BCA & Access Assessment Report

Project Atlas Data Centre
10 Roberts Rd, Eastern Creek NSW

Revision A

13 April 2026

1 SSDA A09 PLN 00 - GF SIGNAGE PLAN
1 : 750

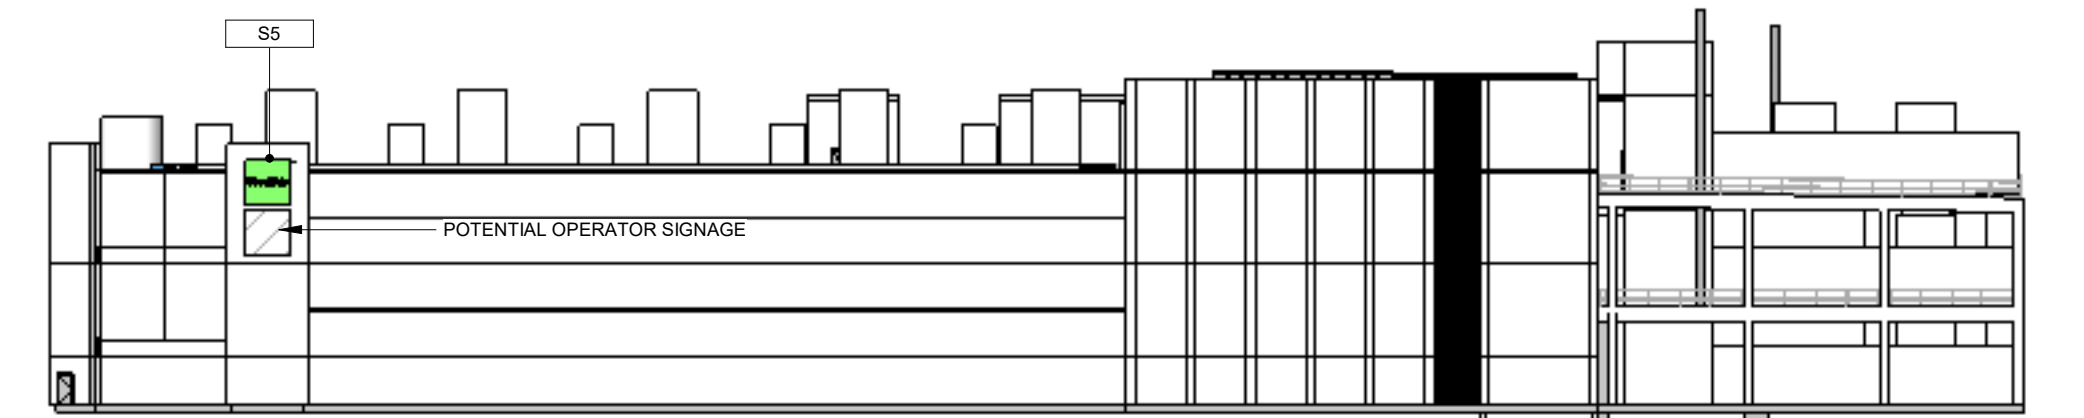
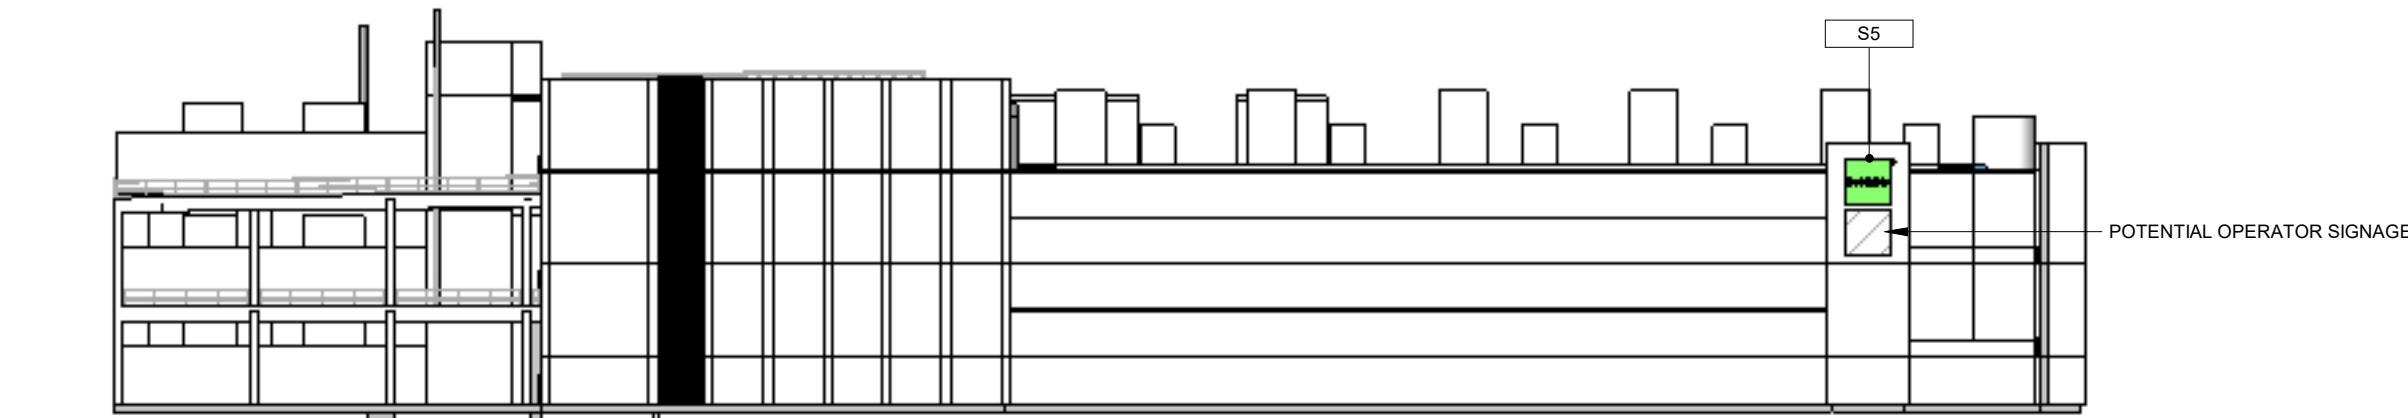
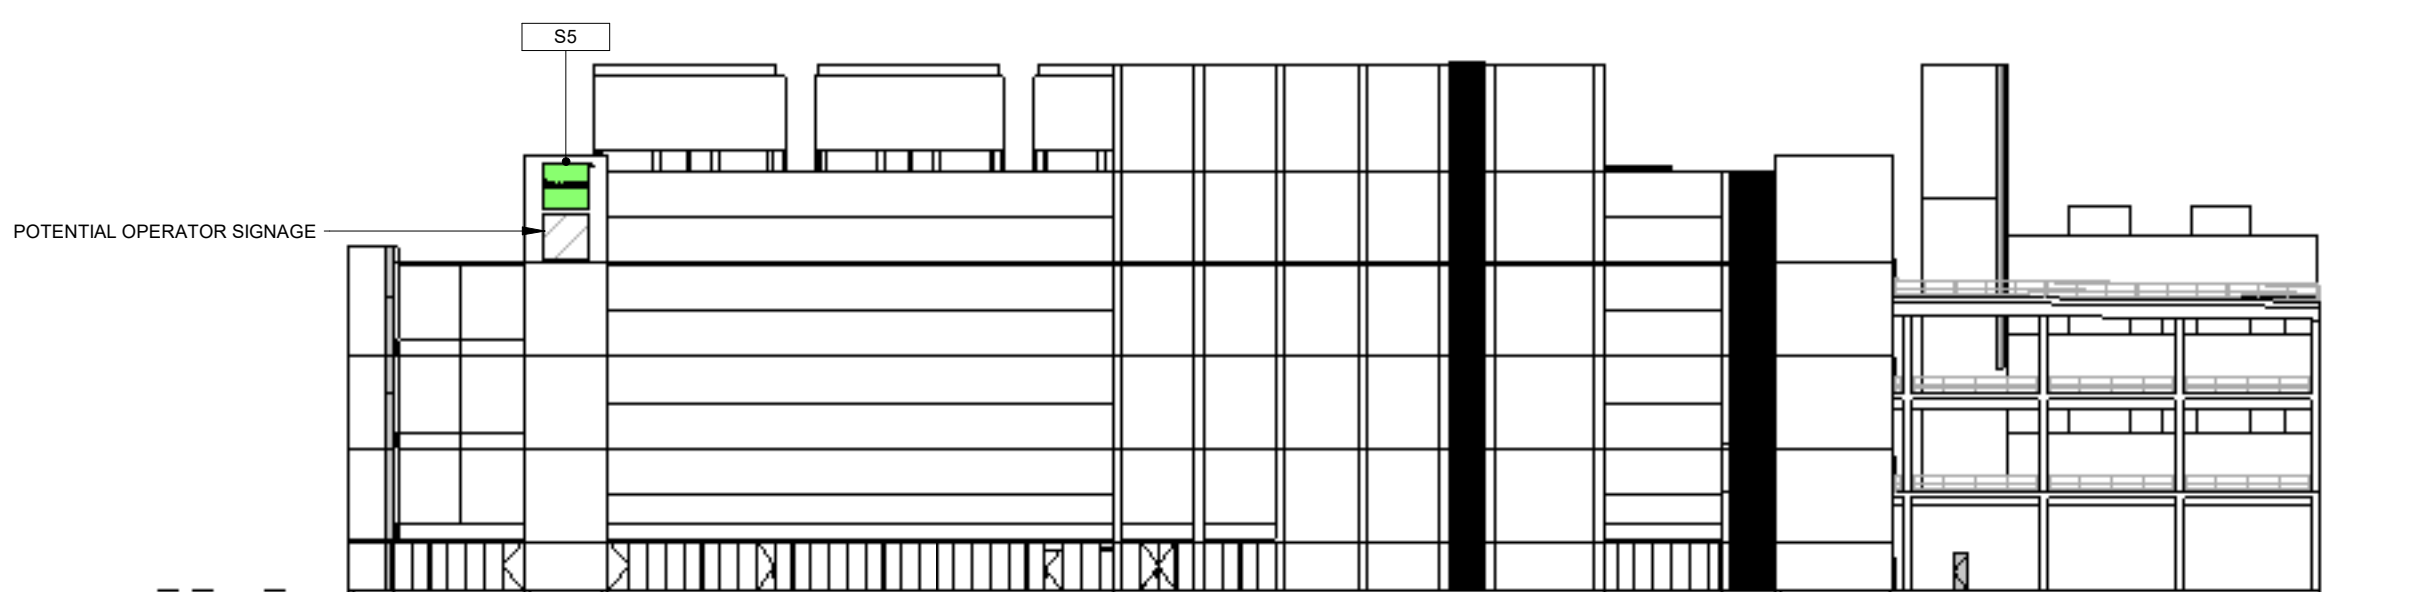
+ BCA (DtS) Clause	+ Description
1. Spec.5	Rationalisation of FRLs applicable to the Class 7b portions of the building – TBC.
2. C2D14	Non-compliant / combustible signage installation on the building facades.
